Our ref: HE548643-ARC-GEN-A585-LE-ZM-4043

30 August 2019

**A585 Windy Harbour to Skippool Improvement Scheme ("the Scheme")**

Status	FOR INFORMATION	Revision	05
Scale	1:2,500		
Drawn	T.Rankin		
Checked	P.Thomas		
Approved	N.Henderson		
Project No	UA009921	Original Size	A3
Drawing Number:	HE548643-ARC-LLO-SZ_ZZ000_DR-D-3036

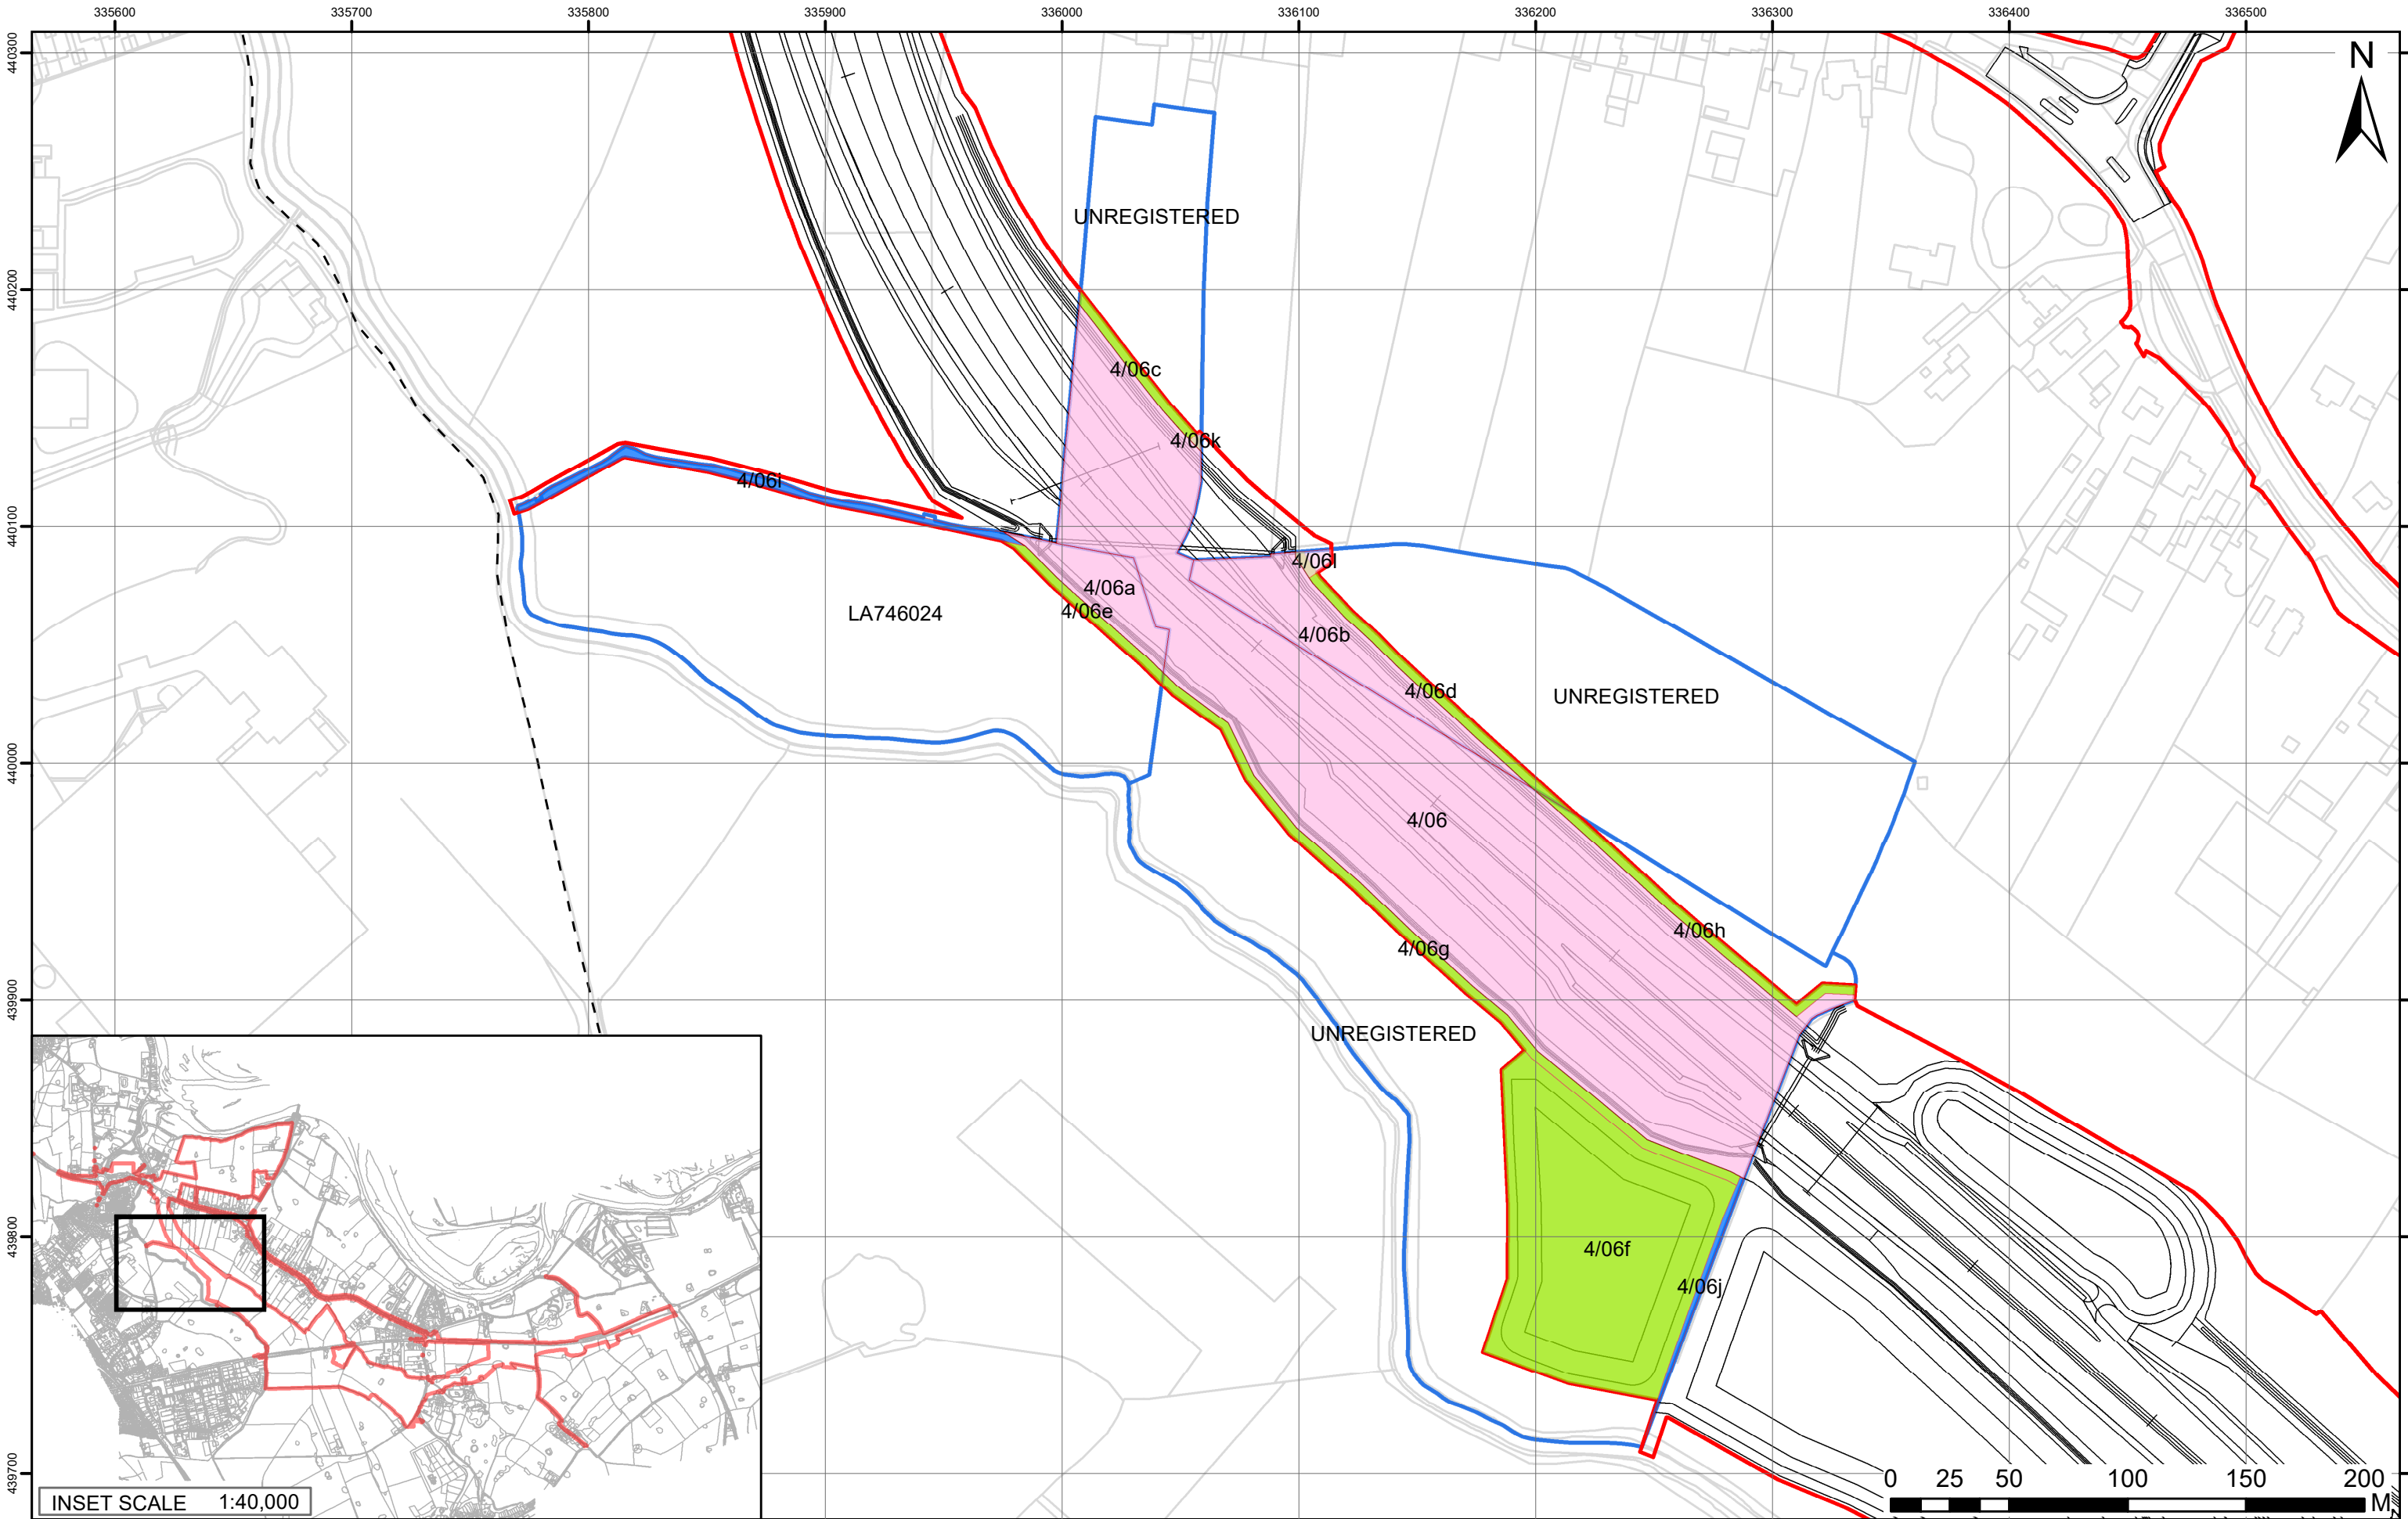
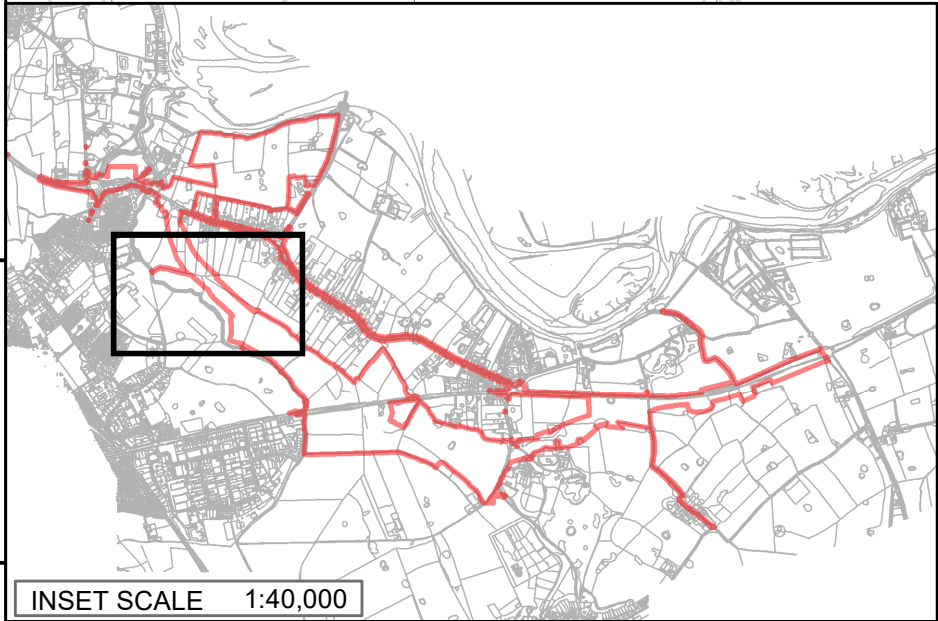
Following your request that your plots of land to the north of the Scheme remain connected once the bypass is constructed, Highways England is proposing to make various changes to the Scheme within the vicinity of your land, including:

- Provision of a link to the main farm land with the plot to the north-east of Culvert 1 as the bypass severs the northern land parcel
- Construction of a farm access track 3.5m wide within a nominal width of 5.5m
- Provision of accommodation fencing on the north side of the access track
- Provision of farm gates at both ends of the access track
- Provision of an accommodation culvert (0.9 metre diameter) across the ditch to the north-east of Culvert 1

You will see that, in order to carry out the changes, Highways England will need to change the extent of the land acquired from you as follows:

Plot	Current Proposal	Proposed Change
4/06c	Temporary Possession	Reduce area by 18 square metres
4/06k	Permanent Acquisition	New plot for access track comprising 22 square metres
4/06l	Permanent Acquisition	New plot for access track comprising 122 square metres
4/06d	Temporary Possession	Reduce area by 46 square metres
